Section 73 of the Town and Country Planning Act 1990

Application to Vary Planning Permission Ref: 2025/62/91965/E

Site: Land at Gelderd Road, Birstall, Batley, WF17 9LS

On behalf of our client, Tesla Motors Ltd, we hereby submit an application under Section 73 of the Town and Country Planning Act 1990 to vary Conditions 2, 9, 15, 17, 18 and remove Condition 16 attached to planning permission ref. 2025/62/91965/E for the installation of electric vehicle charging infrastructure at land off Gelderd Road, Birstall, Batley WF17 9LS.

PROPOSED PLANS &
3D VIEWS ON STAIRS

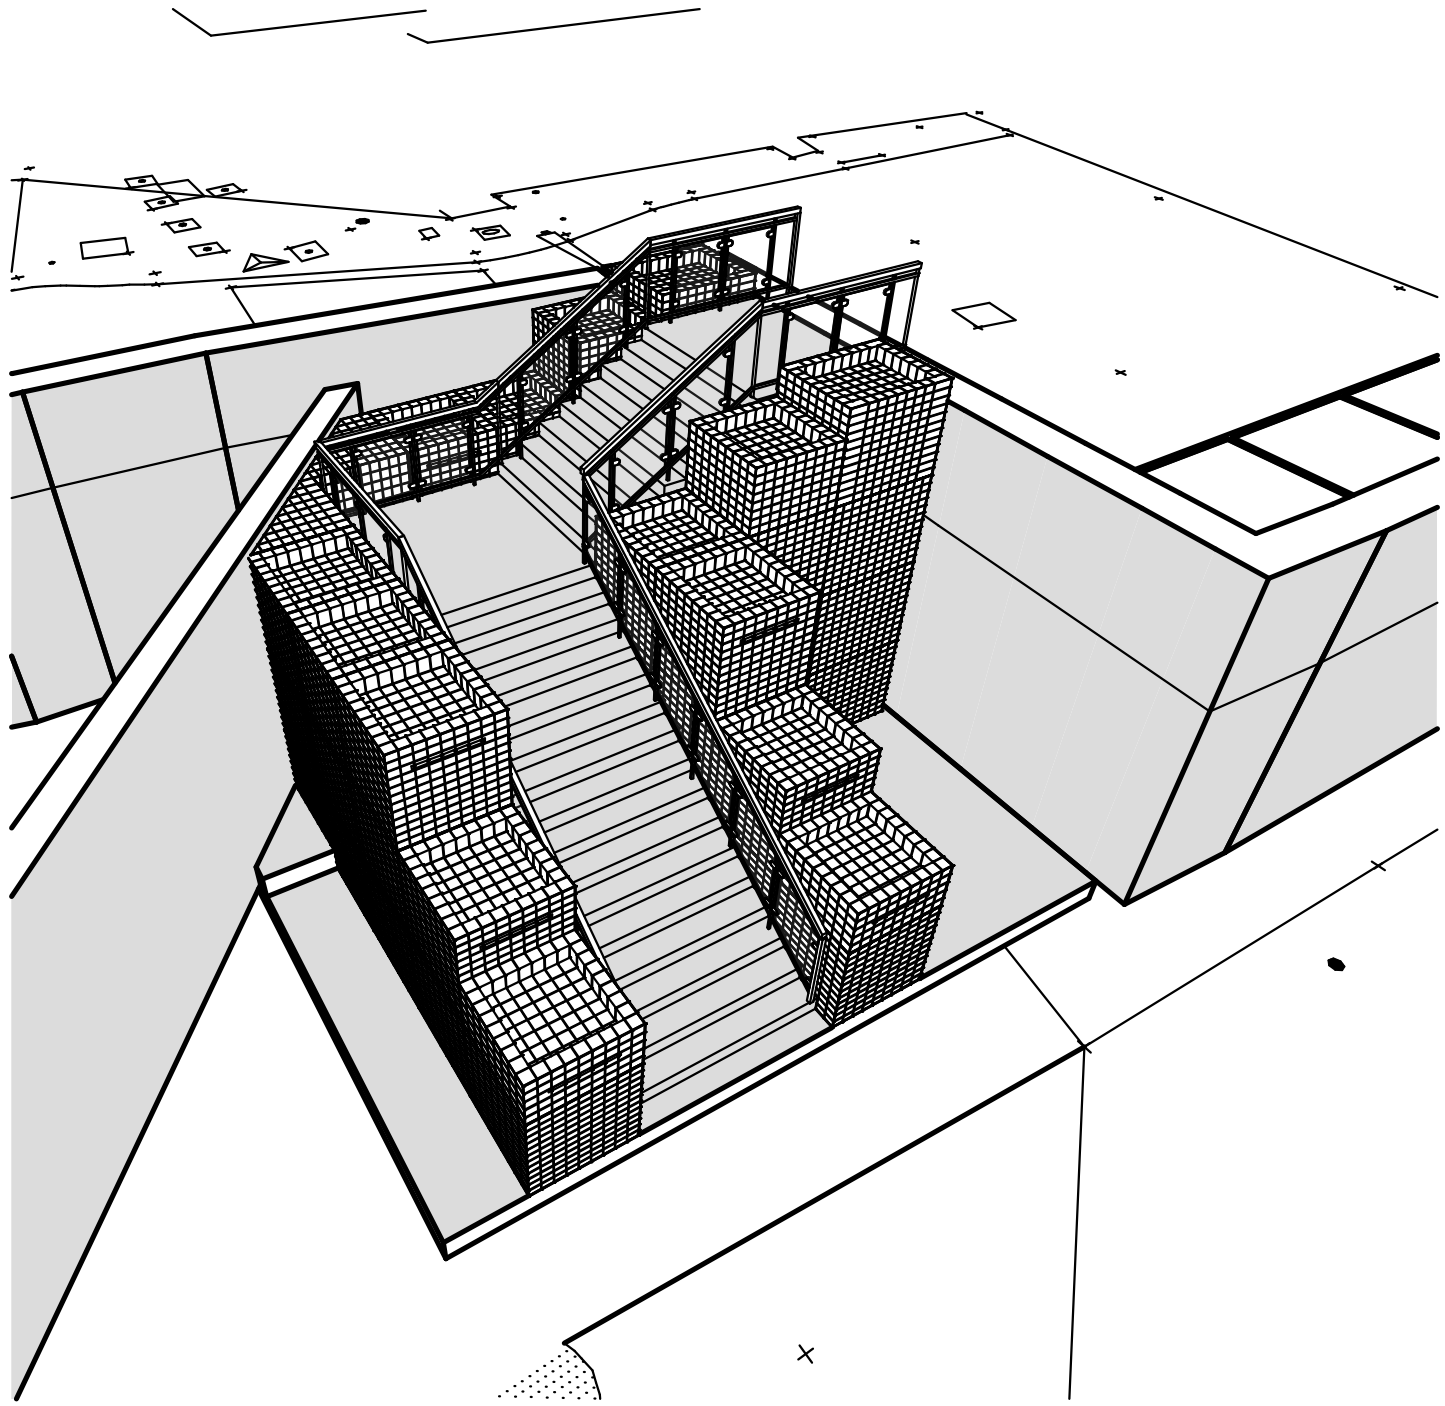
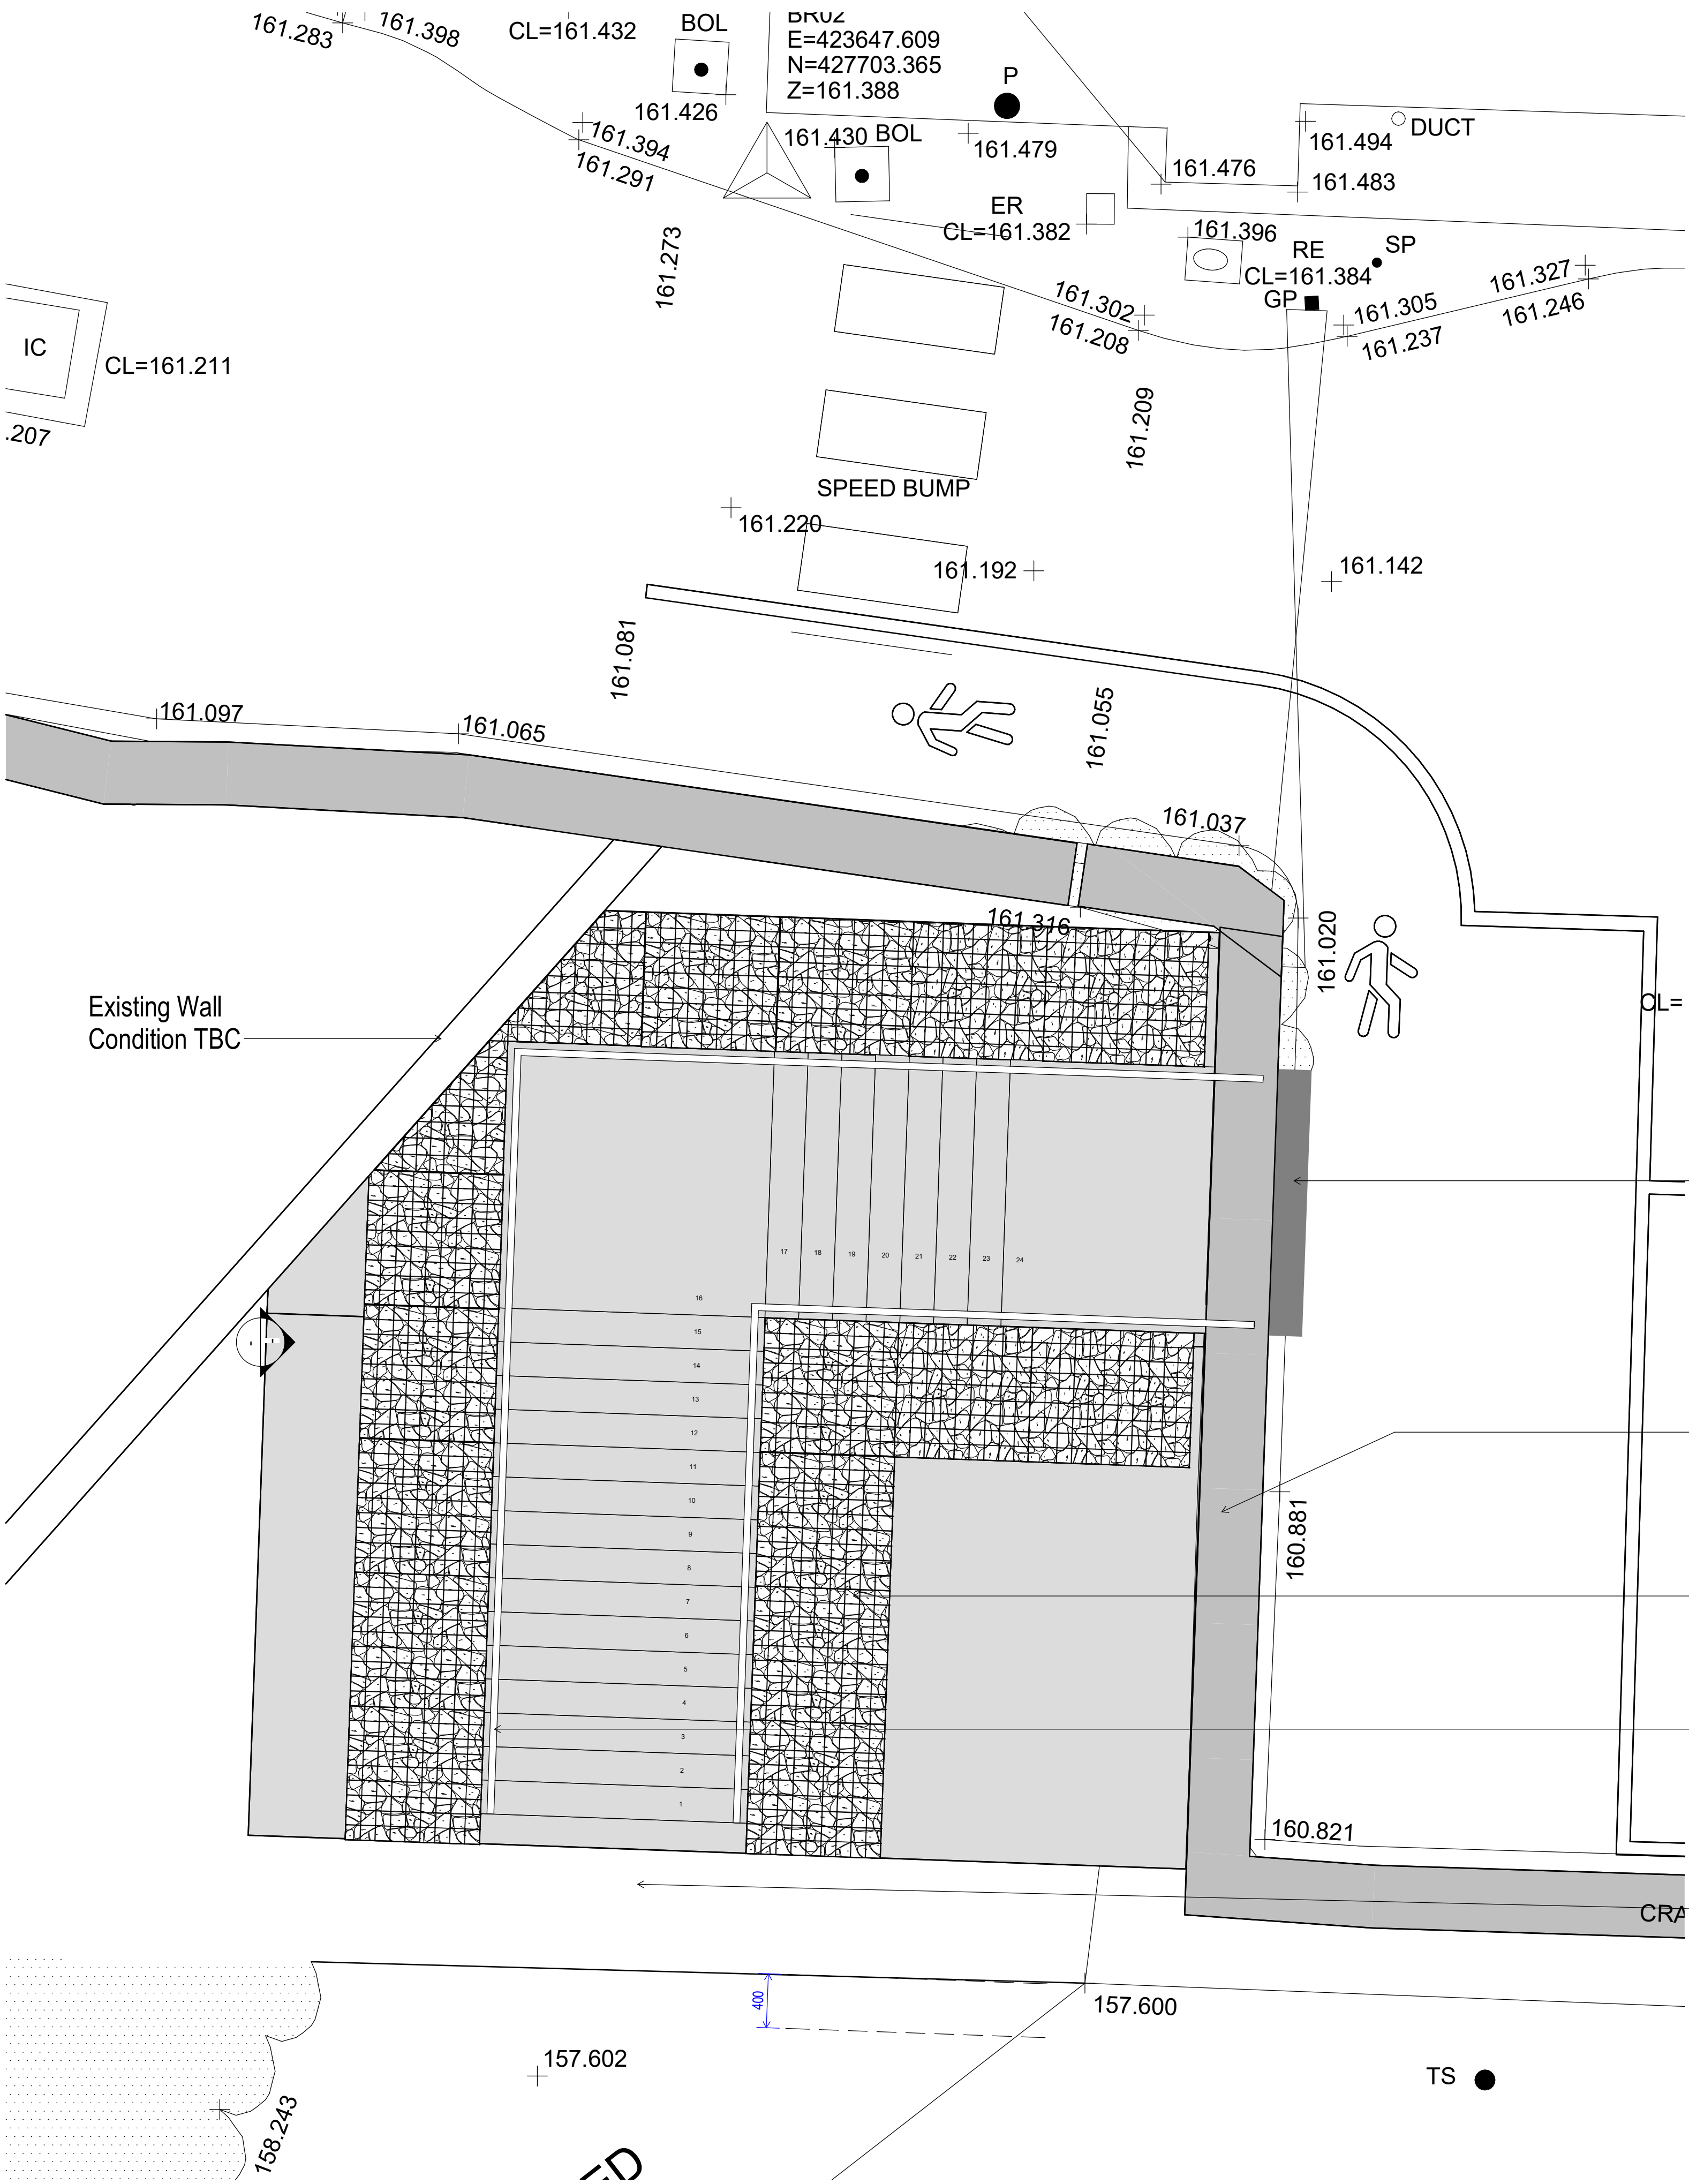
In addition, a minor change is proposed to the proposed staircase. The proposed amendment relates to the reconfiguration of the external staircase and associated landing arrangement. The overall design

The principal change is the orientation of the upper landing and exit point onto the retail park. Following a detailed review of pedestrian movement patterns, the staircase has been amended to provide a more intuitive and logical point of arrival within the retail park. The revised arrangement allows users to enter the site via a dedicated landing area before continuing their onward journey, creating a clearer and more legible pedestrian route that better reflects the natural desire lines and movement of visitors through the site.

The revised arrangement improves pedestrian circulation and accessibility whilst maintaining the original design objectives of the scheme. The amendment does not result in any significant changes to the scale, massing, or visual impact of the staircase structure. The proposed materials, lighting strategy, gabion wall treatment, and landscaping elements remain consistent with the approved design, ensuring the development continues to integrate with the existing site context.

SUPERCHARGING STAIRCASE & PLANTERS

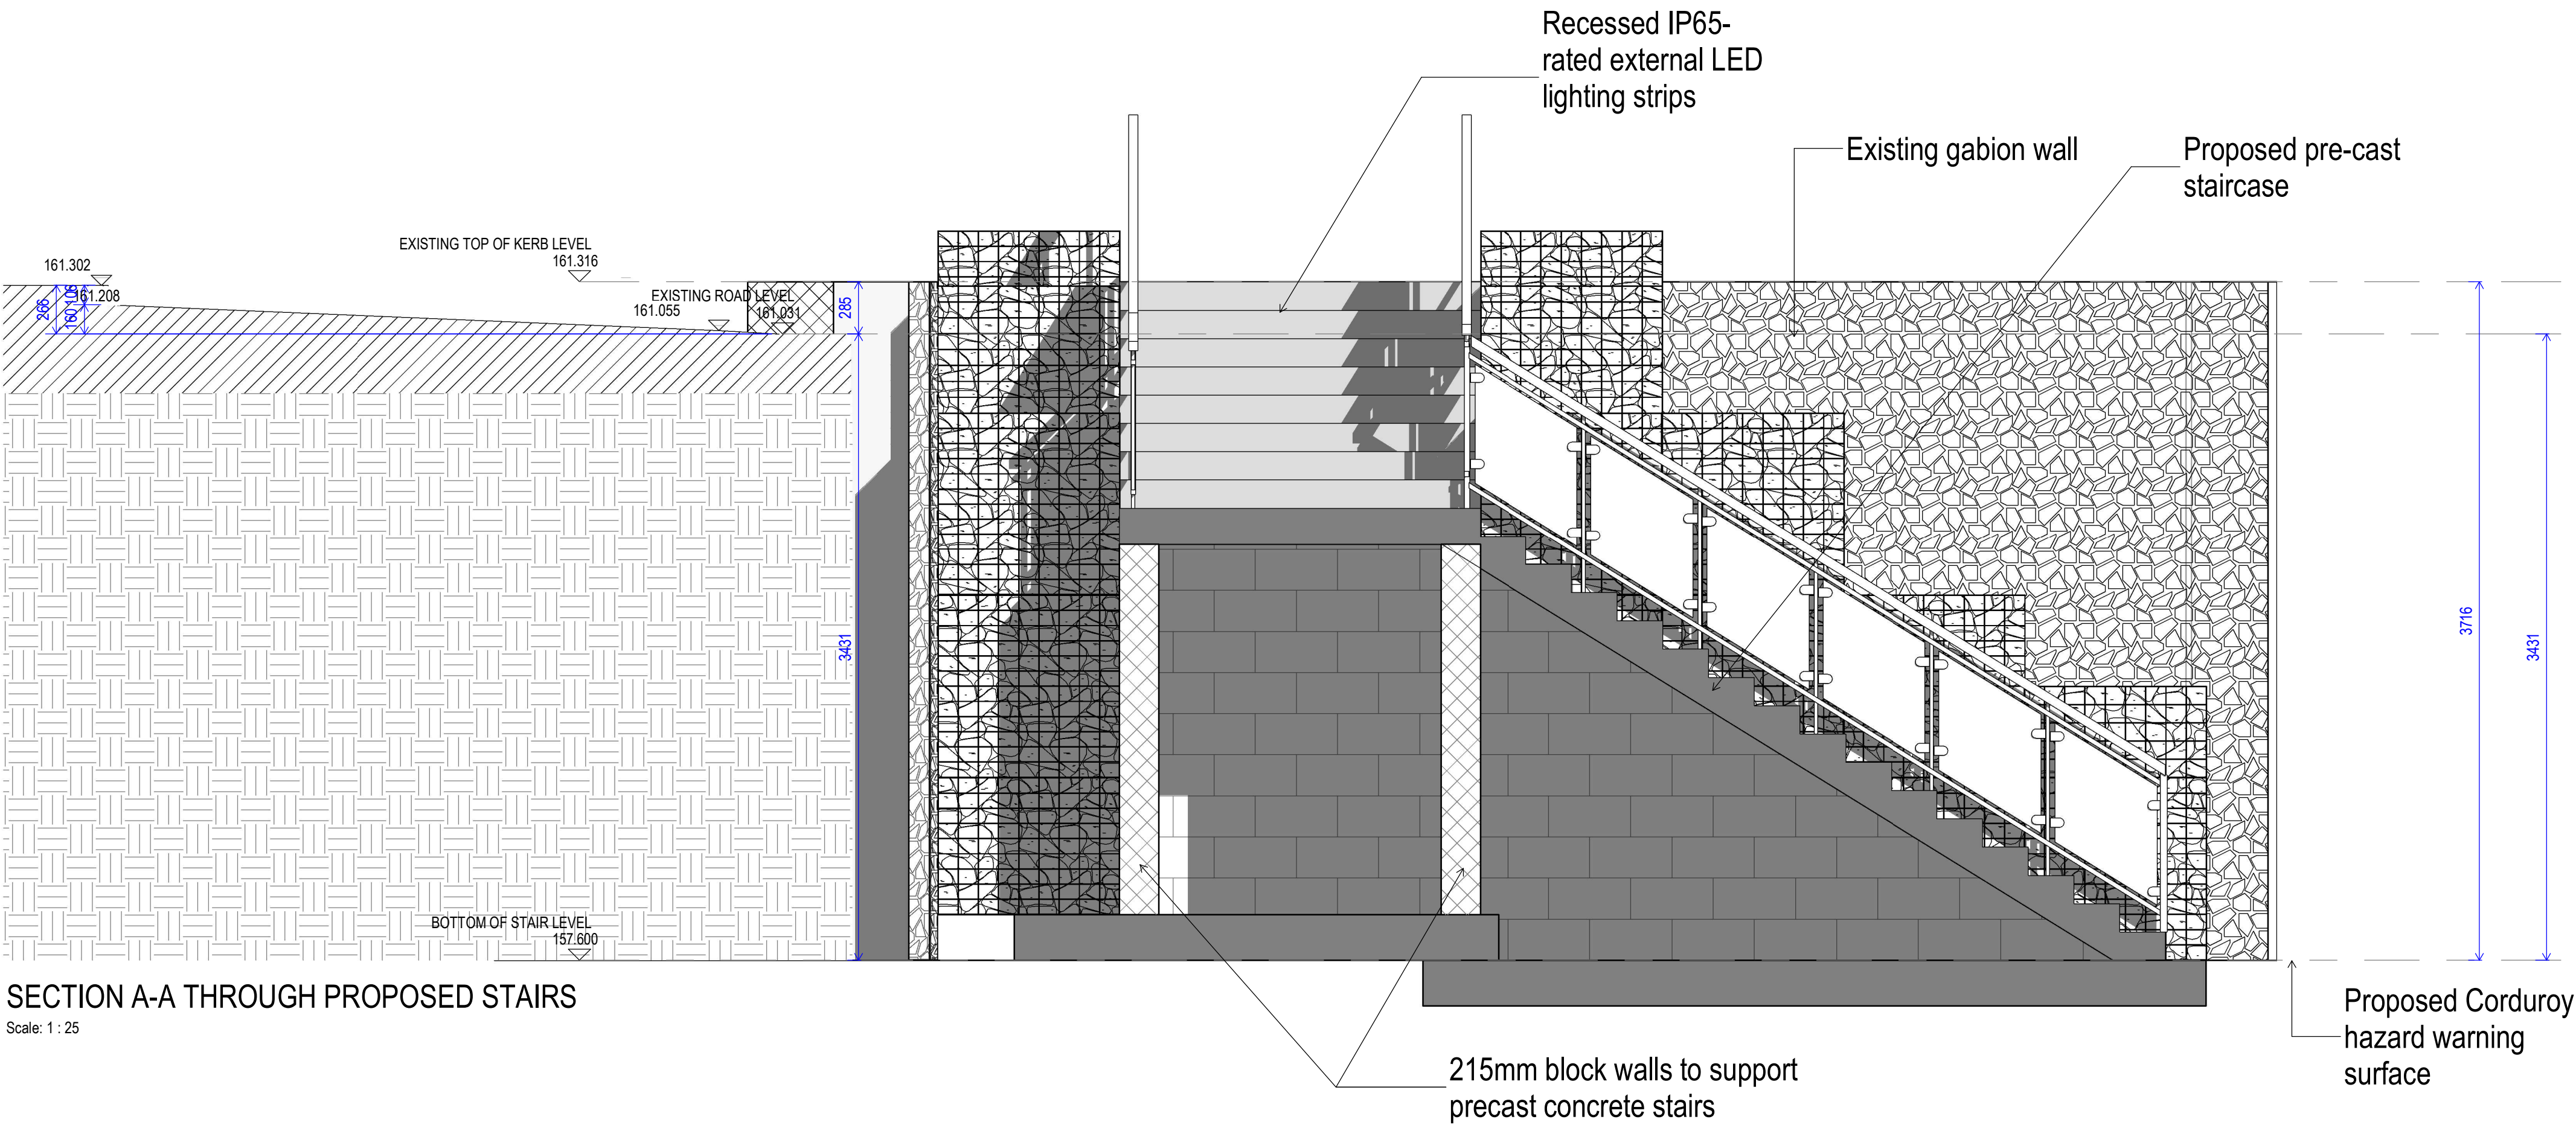
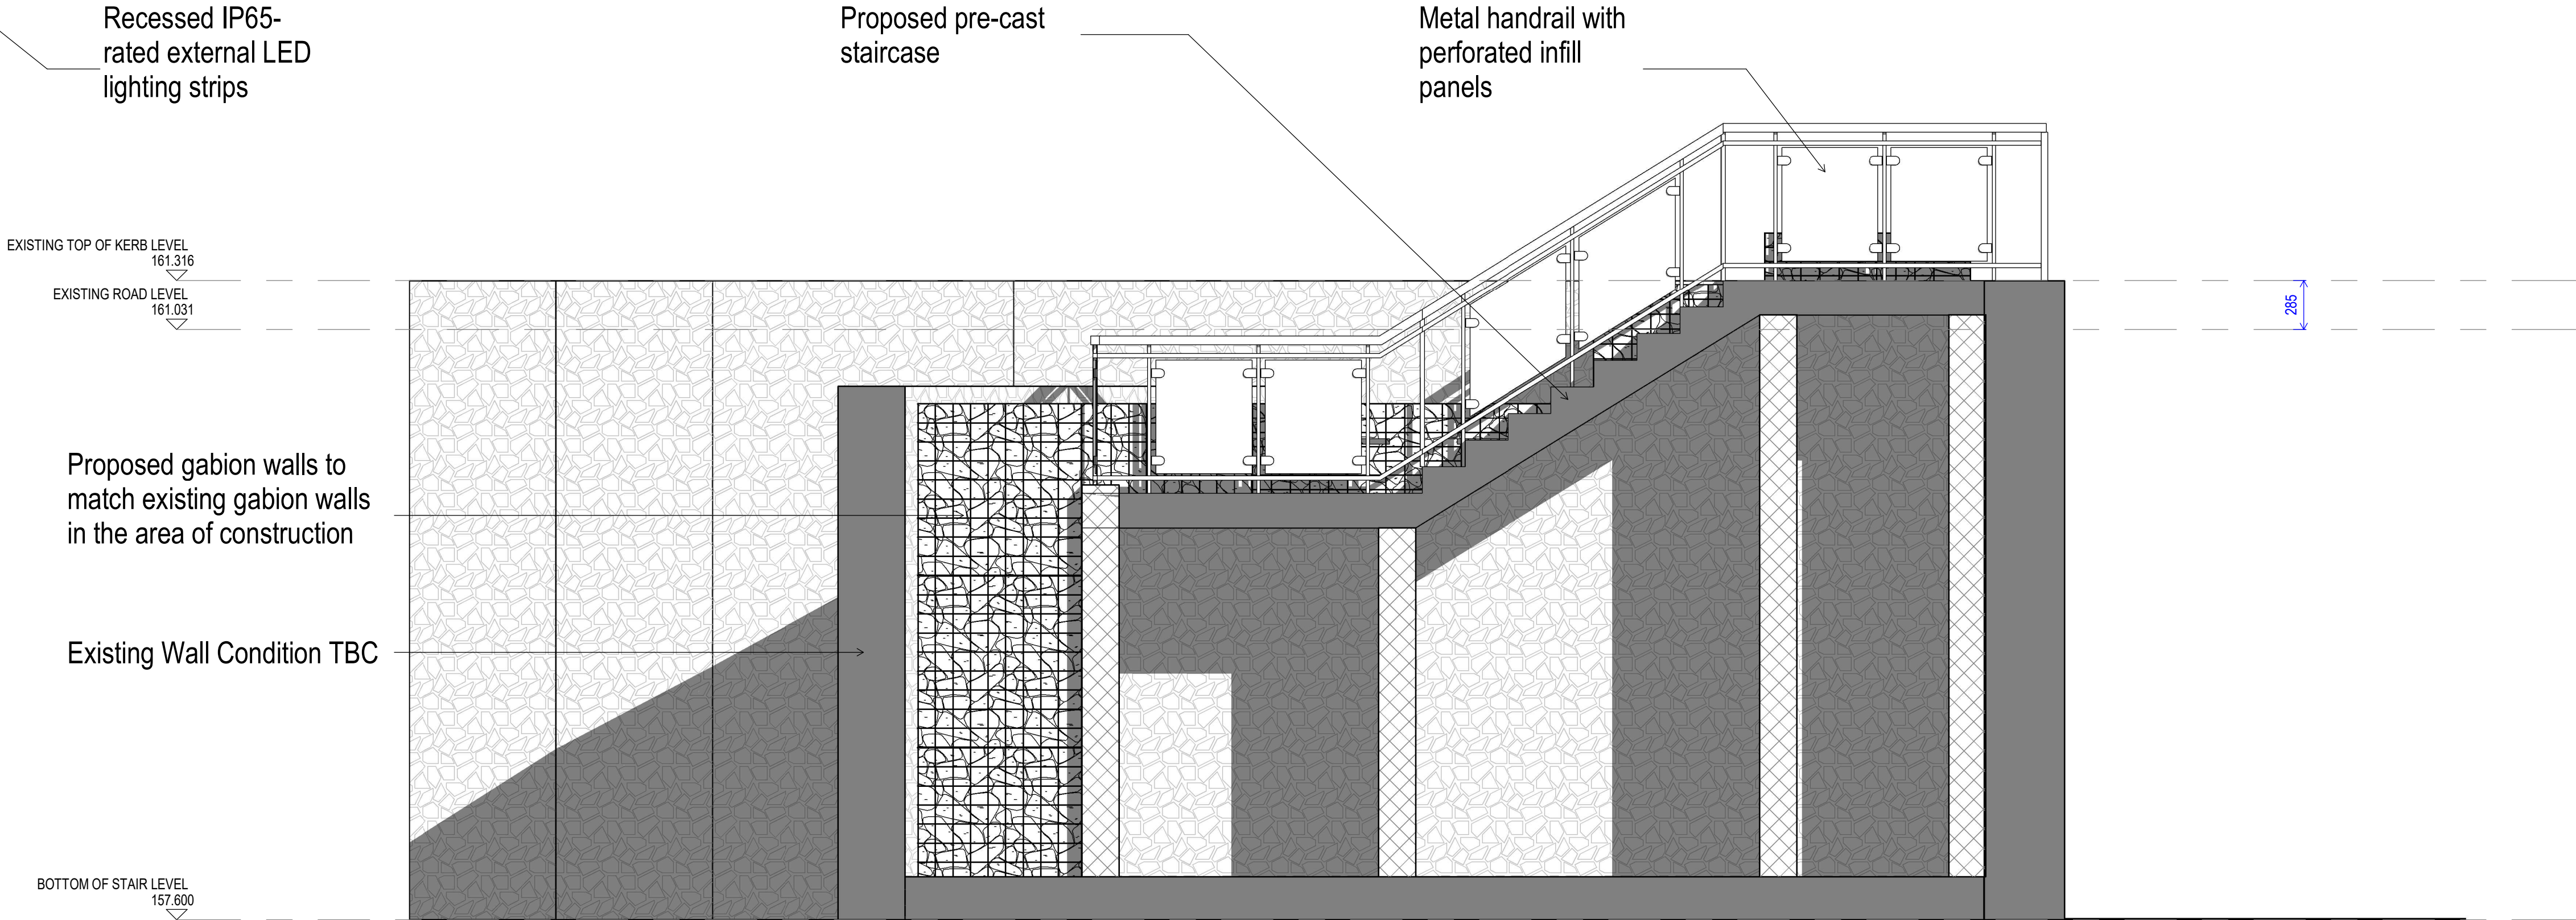
Design. Materials and finish details of the staircase are set out below:

- Gabion baskets: Specified to "match existing installations" and would appear to be locally sourced limestone.
- Handrails: The proposed handrails will be finished in Anthracite Grey (RAL 7016), providing a contemporary appearance that complements the wider material palette of the development
- Precast concrete steps: Finish: smooth.
